Tween Bridge Solar Farm

9.10 Statement of Common Ground with National Highways

Document Reference: 9.10

Revision ~~3~~4

Document Ref: 6.4.6.4 AFPP Reg: 5(2)(a) Revision: 2
 PINS Number: EN010148 Drawing Status: Final
 Drawn: LAB Checked: HS Approved: KC Date: 17/04/2026

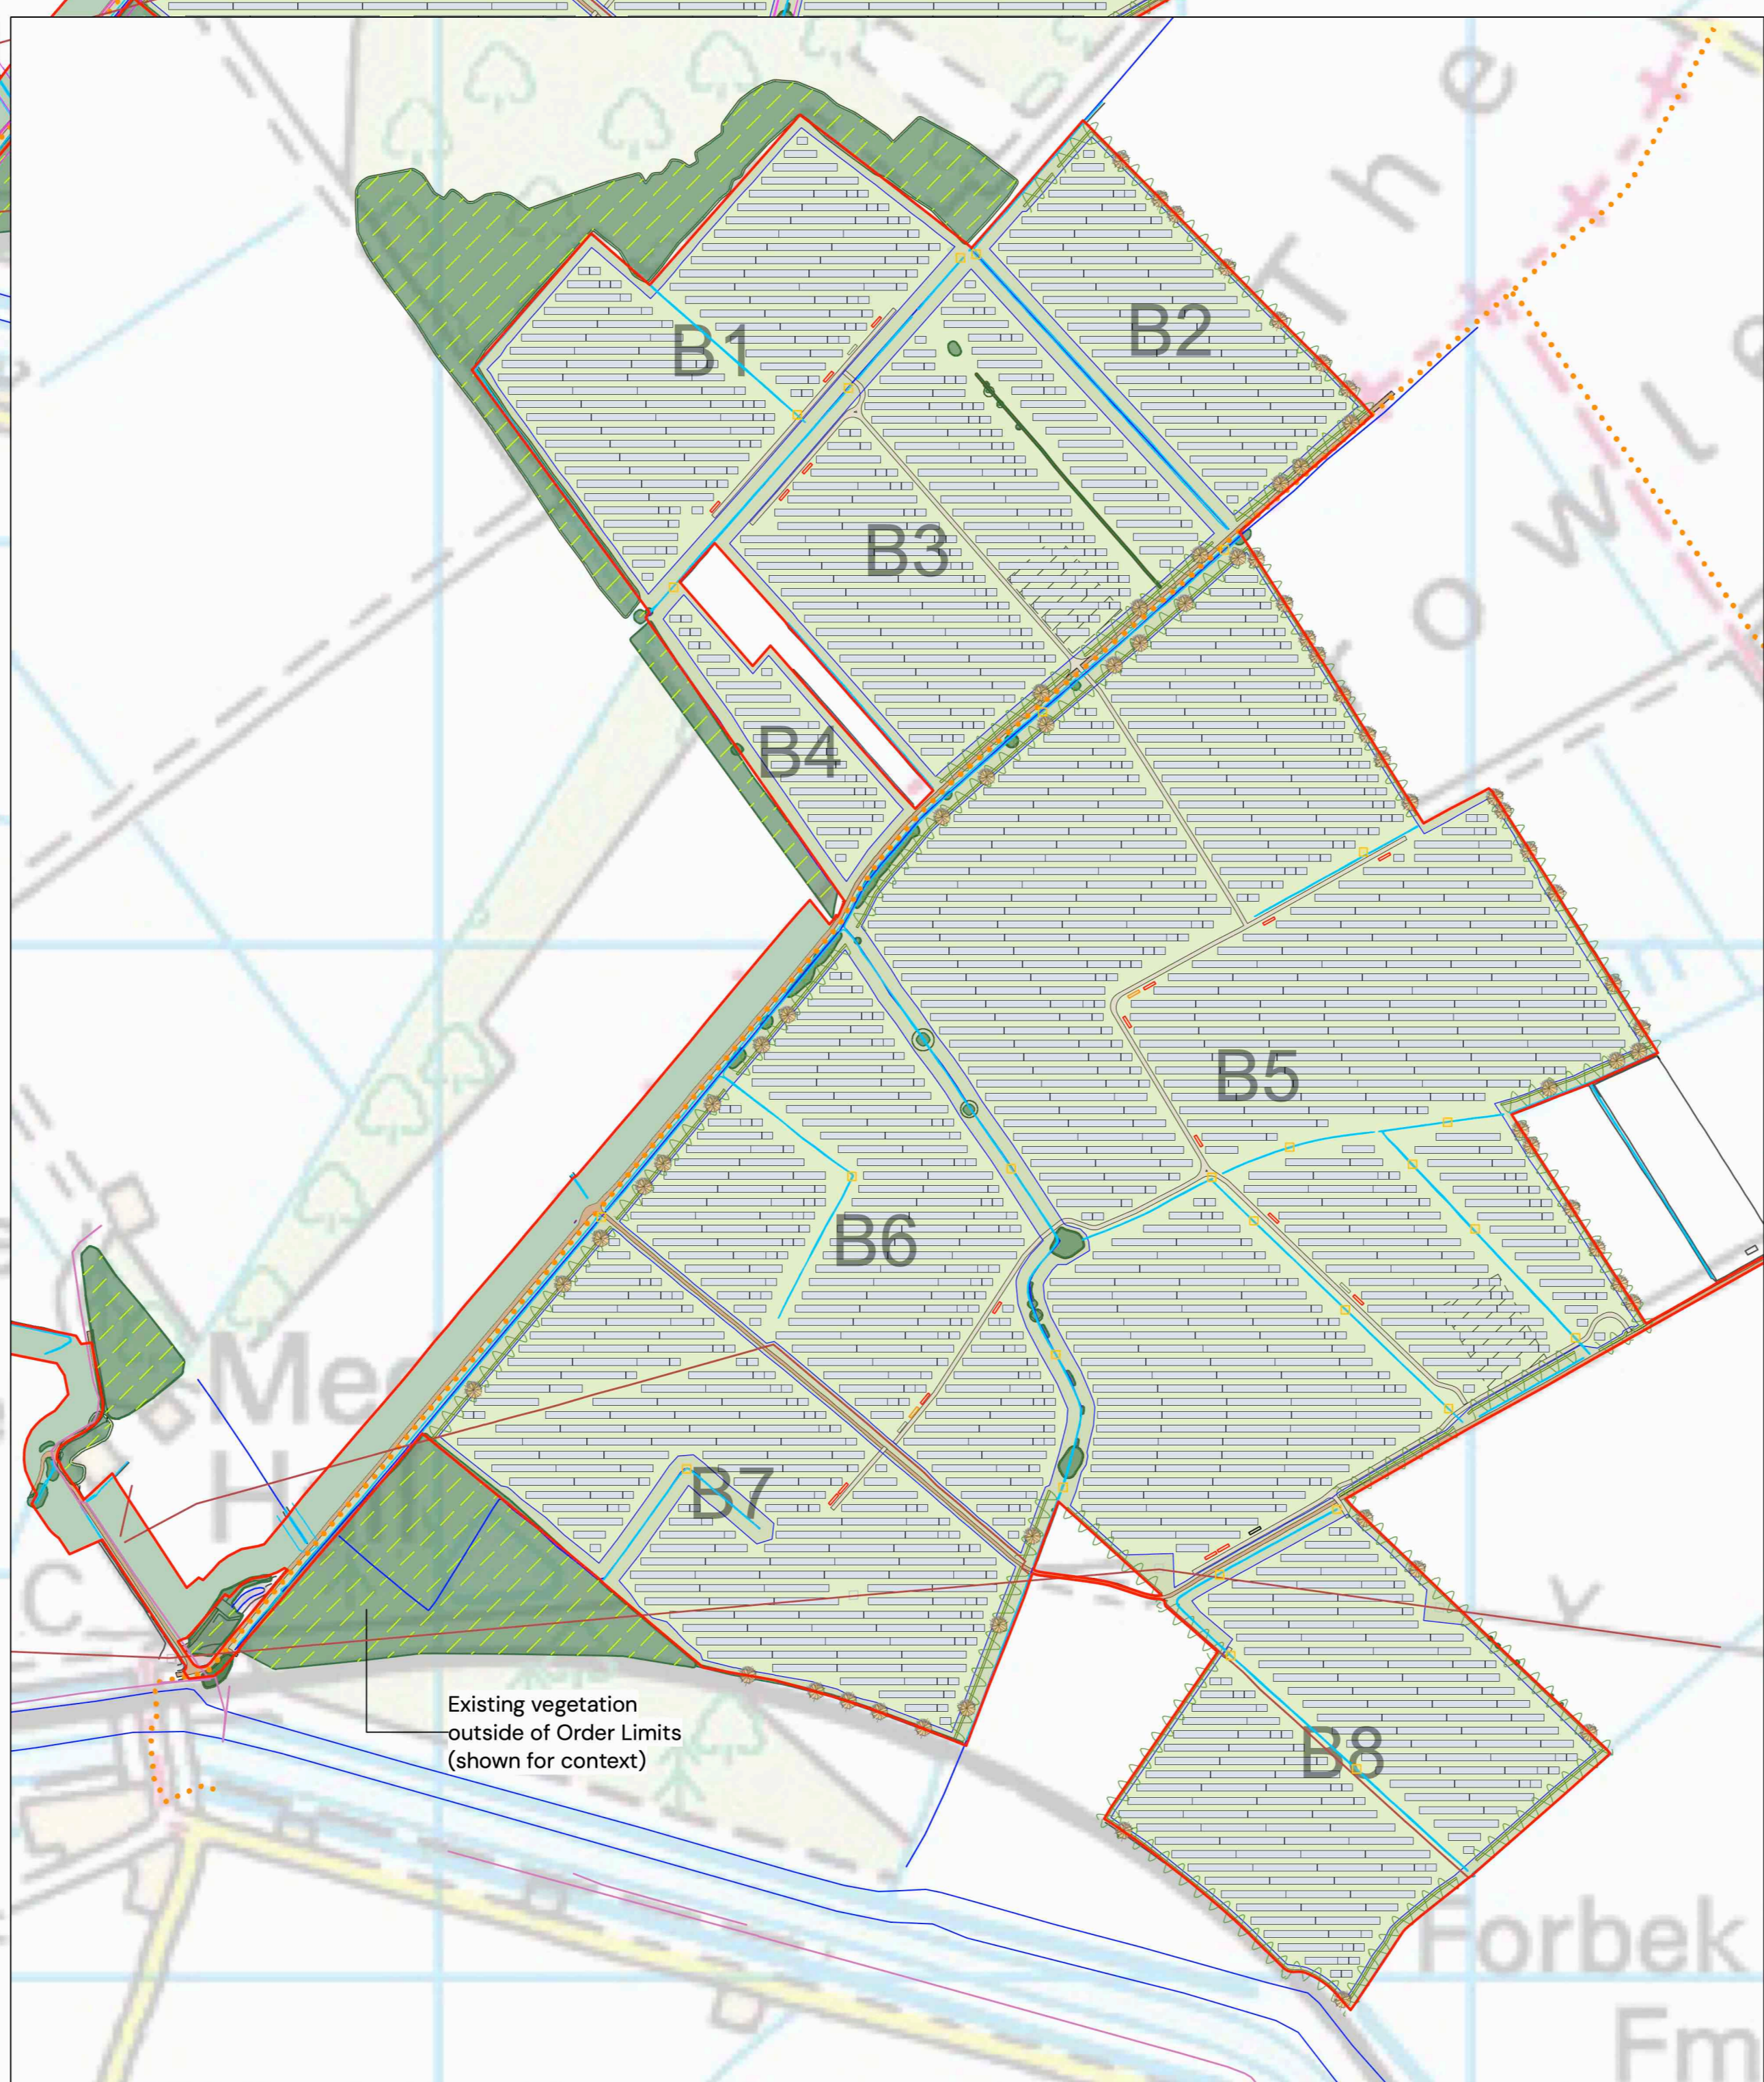
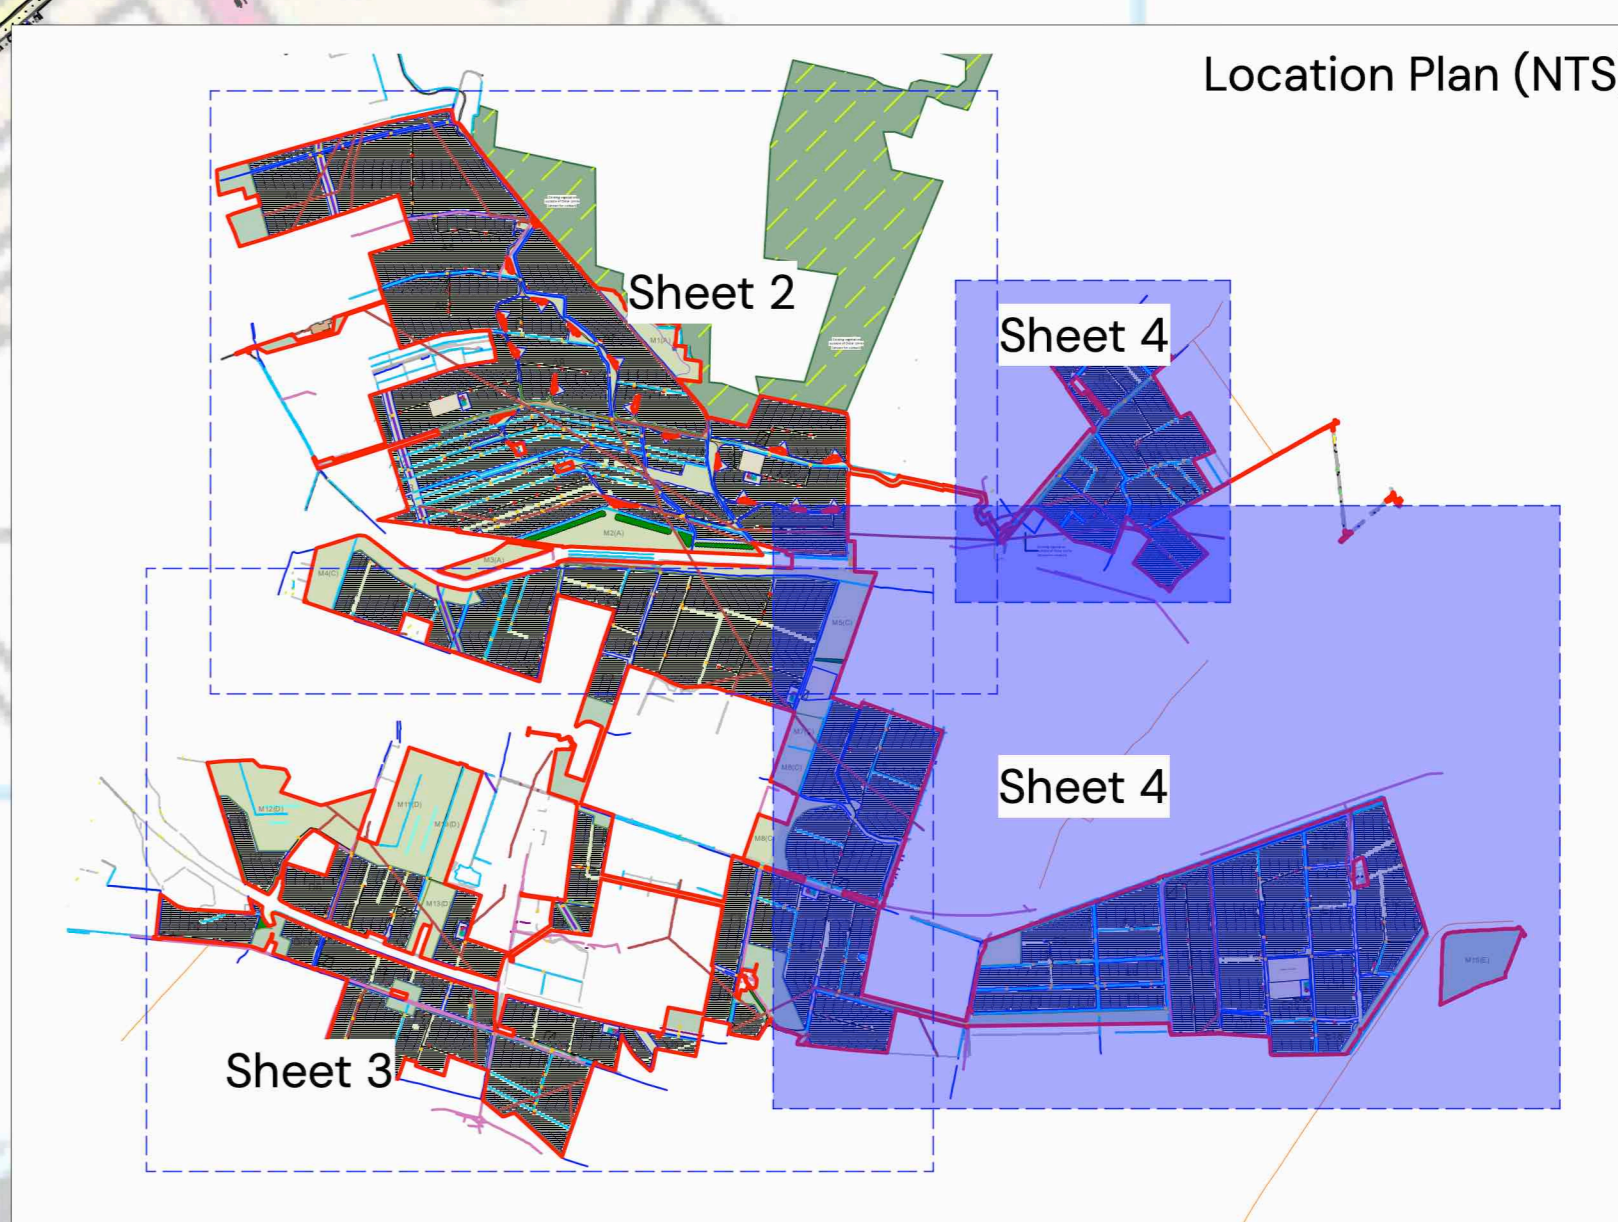
7	Glint and Glare Assessments [APP-122 and REP1-025] and Outline Landscape Ecological Management Plan [REP1-034]	NH notes that no dedicated mitigation is proposed in respect of glint and glare effects. The residual effects of glint and glare can have substantial impact on the safety of road users and it is of critical importance to NH that the mitigation applied in the Landscape Ecological Management Plan is satisfactory and	In the Glint and Glare assessments, mitigation is only required where a high impact is predicted on a road. Environmental Statement Appendices 16.1 and 16.2 [APP-122 and Document Reference 6.3.16.2 Revision 2] REP1-025 and REP1-026 conclude that a moderate	Under discussion

suitably maintained to enable establishment. The Applicant is also proposing additional planting in existing planting areas in close proximity to the SRN, which would require the approval of NH's environmental team due to the sensitive ecosystem at these locations. NH therefore requires that Requirement 8 of the draft DCO is amended to include NH as an approving body for the detailed Landscape Ecological Management Plan with regard to the specific elements relevant to the SRN (refer to point 9 below). <u>NH notes that the Applicant does not consider it proportionate to include NH as an approving body in respect of this requirement, however NH is only asking that it be made an approving body in respect of those aspects of the detailed Landscape Ecological Management Plan approved under Requirement 8 insofar as it relates to the SRN. No reason is given by the Applicant as to why it would be disproportionate to include NH in this capacity, given its clear and obvious interest and the need to ensure that the</u>	impact is predicted on separate 0.2km and 1.6km sections of the M180, and a 0.1km section of the A18. On the basis that the predicted impact is moderate, mitigation is not deemed to be required. However, planting has nonetheless been proposed as part of the Scheme to reduce the effect further over time. The Applicant agrees that appropriate provision must be made for the ongoing management and maintenance of planting. The proposed management prescriptions for retained and proposed planting are set out in Table 4-1 of the Outline Landscape Ecological Management Plan [Document Reference 7.6 Revision 25] submitted at Deadline 1. The location of the proposed mitigation planting to screen views of the fencing and panels and in turn to mitigate glint and glare effects are set out on the drawings at ES Figure 6.4 Landscape and Visual Mitigation Strategy

matters which relate to NH's functions). The Applicant considers that this approach is sufficient and appropriate in the circumstances, and it would not be proportionate to include National Highways as an approving authority under Requirement 8. <u>No precedent has been cited in support of National Highways' suggested approach to the drafting of Requirement 8 and the Applicant fails to see how the relevant planning authority is not competent to act as discharging authority in respect of all matters pertaining to the LEMP, particularly in circumstances where National Highways will have been consulted on the LEMP and will have had an opportunity to make its views known, prior to the submission of the same to the relevant planning authority for approval.</u>	
8	Drainage	NH notes the clarification received from the Applicant that it does not currently anticipate any proposals to outfall surface water runoff into highway	ES Technical Appendix 10.1 Flood Risk Assessment Parts 1, & 2, and 3 [Document Reference 6.3.10.1 Revision 2 REP2-047, REP2-049,	Under discussion <u>Agreed</u>
